SUBMISSION

EIS: Mandalong Mine Southern Extension Project SSD5144

VERSION TWO: this document has additional information and replaces the first version lodged on 9/10/13. This Version Two document was submitted in two parts due to online transmission size restrictions. This is **Part one of two** documents.

Figure 53 – Assumed Location of Construction Noise Sources for Access Road and Site Excavation

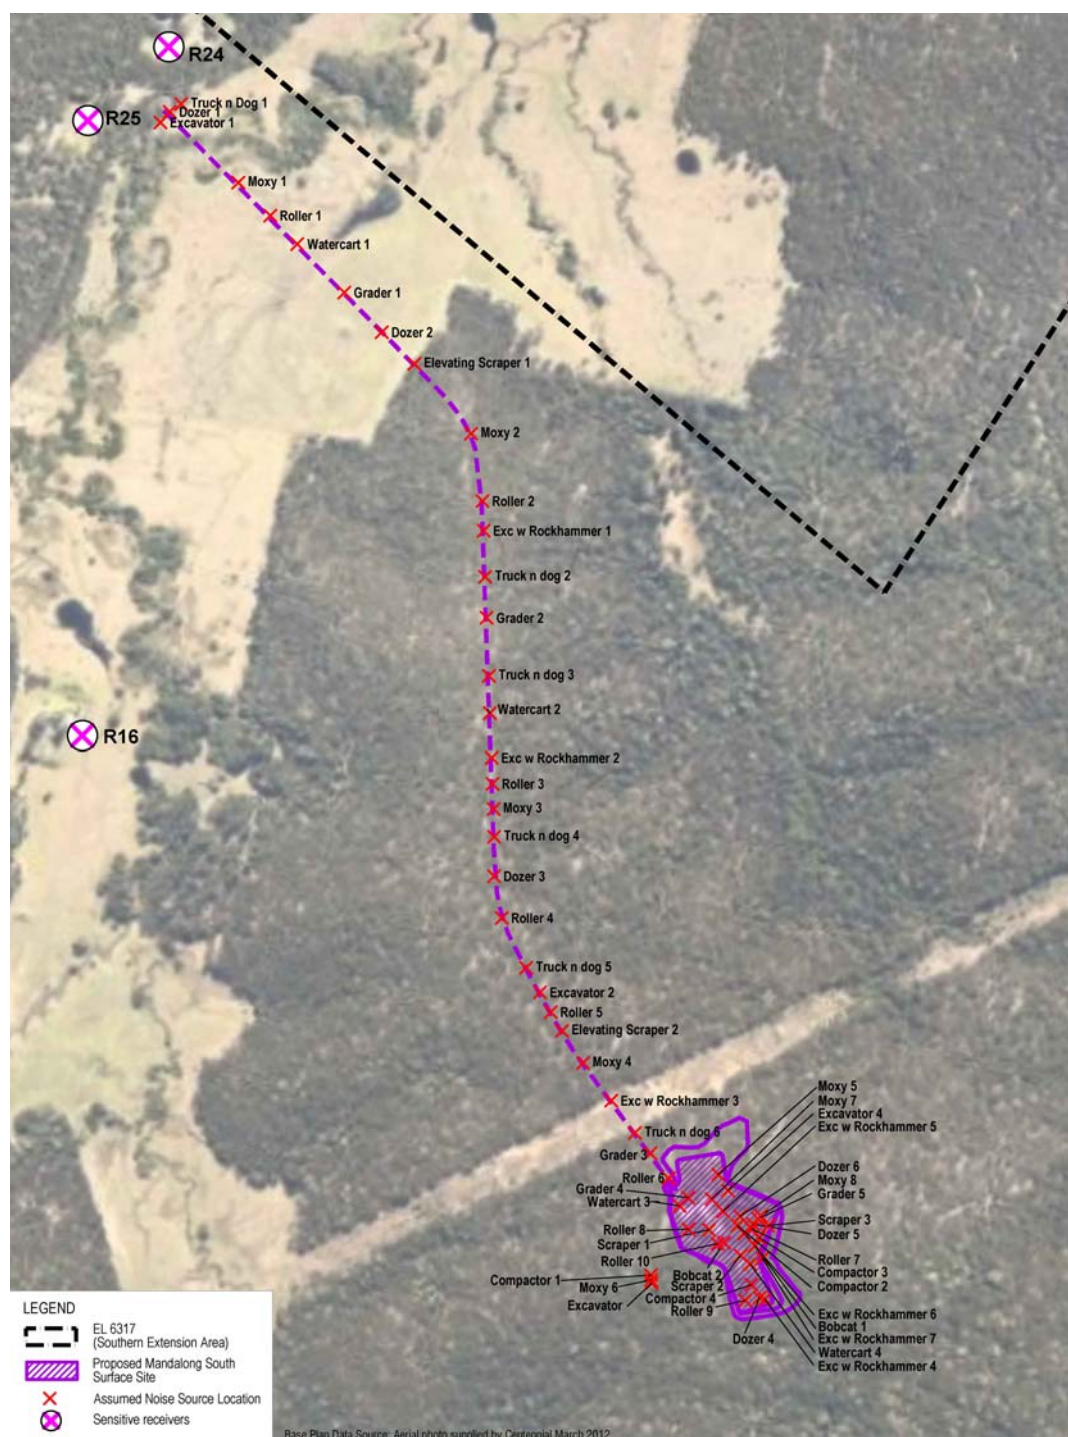
The EIS Noise Assessment outlines how the project will exceed noise target levels but states that it should be possible to reduce noise levels by up to 10dB at sensitive receivers. Table 54, “*Construction Noise Modelling Results – Access Road and Site Excavation*” (p278 of EIS Document No. 21) shows that without mitigation, the predicted construction noise will exceed the “*noise affected level (between 40-44 dBA) by up to 18 dBA, in particular those residents R24, R25 and R26 located near the junction of Mandalong road and the proposed access road*”. The mitigation measure proposed is the use of noise barriers 2m high which is predicted would reduce noise at R24 by 7dBA and a reduction of 1dBA at R25 and a reduction of 10dBA at each residence is achievable (as shown in Table 55 of EIS Document No. 21). It would be appropriate for modelling of the specific noise management measures to be provided. This would include noise contour maps for each stage of construction to see the predicted impact.

- The EIS states that noise mitigation measures suggest it is possible to reduce noise to acceptable levels, however cumulative noise and mitigation impacts have not been modelled for the construction phase. Modelling needs to be undertaken, and noise contour maps provided to the community.

Figure 54 – Assumed Location of Construction Noise Sources for Shaft Sinking

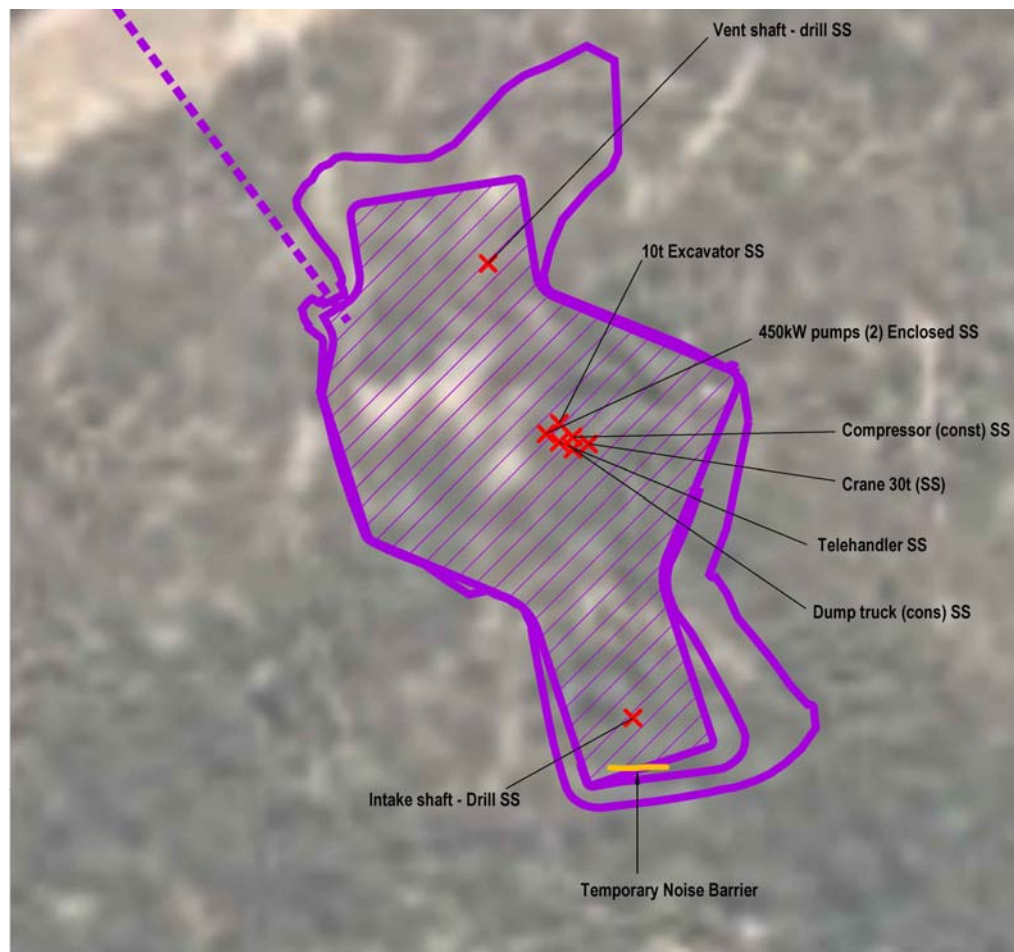
It is stated that the shaft sinking will need to be done outside of standard recommended operating hours and will marginally exceed (by 1dBA to be 36 dBA) the relevant “*noise affected*” level (35dBA) at R20. A mitigation strategy is to install a temporary barrier measuring 7m high and 20m long to provide acoustic shielding, as well as using equipment with a reduced sound power level. The EIS Noise Assessment states that Centennial Coal will use all “*reasonable and feasible*” noise mitigation measures to reduce impact. However, it is unclear whether the mitigation measures proposed are the only measures that are considered to be “*reasonable and feasible*” and what level of benefit would be provided by implementing all “*reasonable and feasible*” measures.

- Clear and specific information be provided as to what “reasonable and feasible” mitigation measures are proposed and what level of benefit would be provided by implementing all “reasonable and feasible” measures.
